CITY OF ALBUQUERQUE

April 23, 2024

**RE: Honey Well – Docks and Parking Lot
Grading and Drainage Plans
Engineer's Stamp Date: 04/05/24
Hydrology File: B17D001B**

Based upon the information provided in your submittal received 04/08/2024, the Grading & Drainage Plan **is not** approved for Building Permit and Grading Permit. The following comments need to be addressed for approval of the above referenced project:

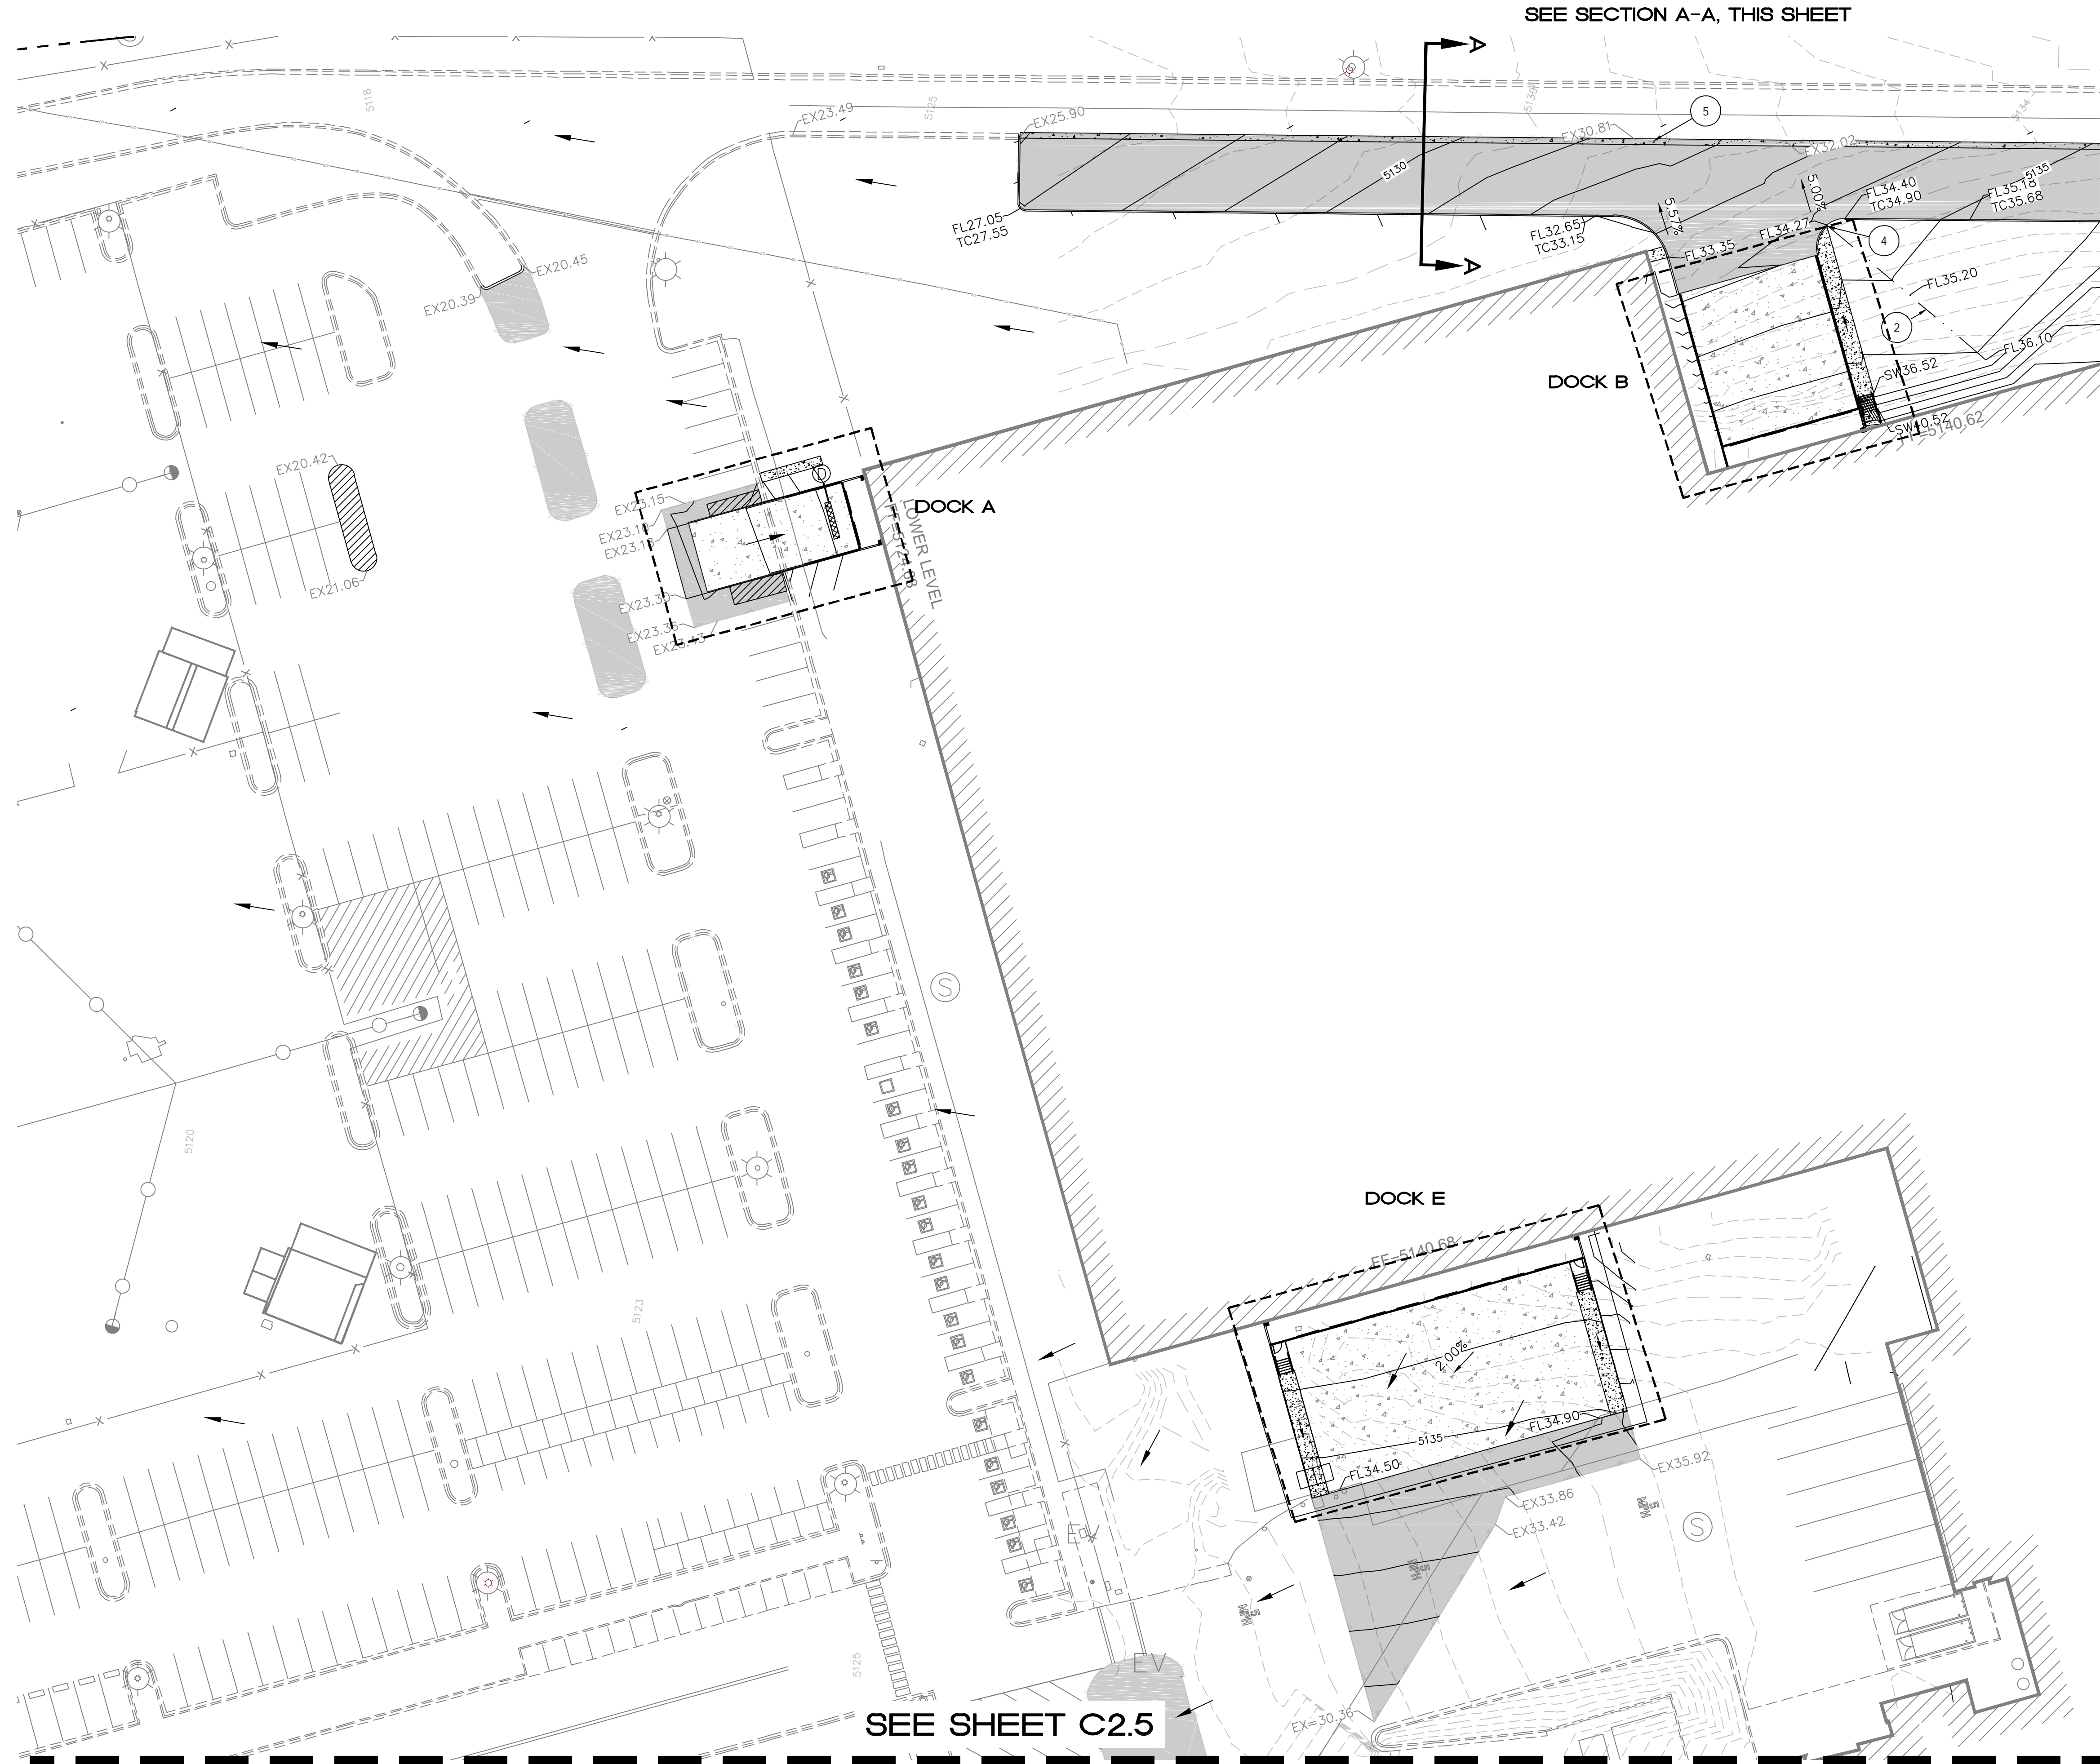
Sheet C 2.4

26. Please clean up the proposed dock areas. There should be no proposed elevations here. All proposed elevations need to be shown on the blow-up Detail of the dock.
27. Please place a thick dashed line around each dock and label "See Dock X Detail. This Sheet."

28. Dock G. There should be an inlet here like all of the other docks which goes down. The proposed pipe can then go to the back of curb in the alley where it can daylight.

29. Again, it is hard to tell what is being constructed here. The proposed pavement disappears in all of the other line work.

30. The last dock appears to have not been designed correctly for a truck to back into. Please review this.

31. Please revisit the required retention pond design. I think that this could be designed a little bit better but please keep in mind to keep a side slope of 3:1 or provide a retaining wall if need be.
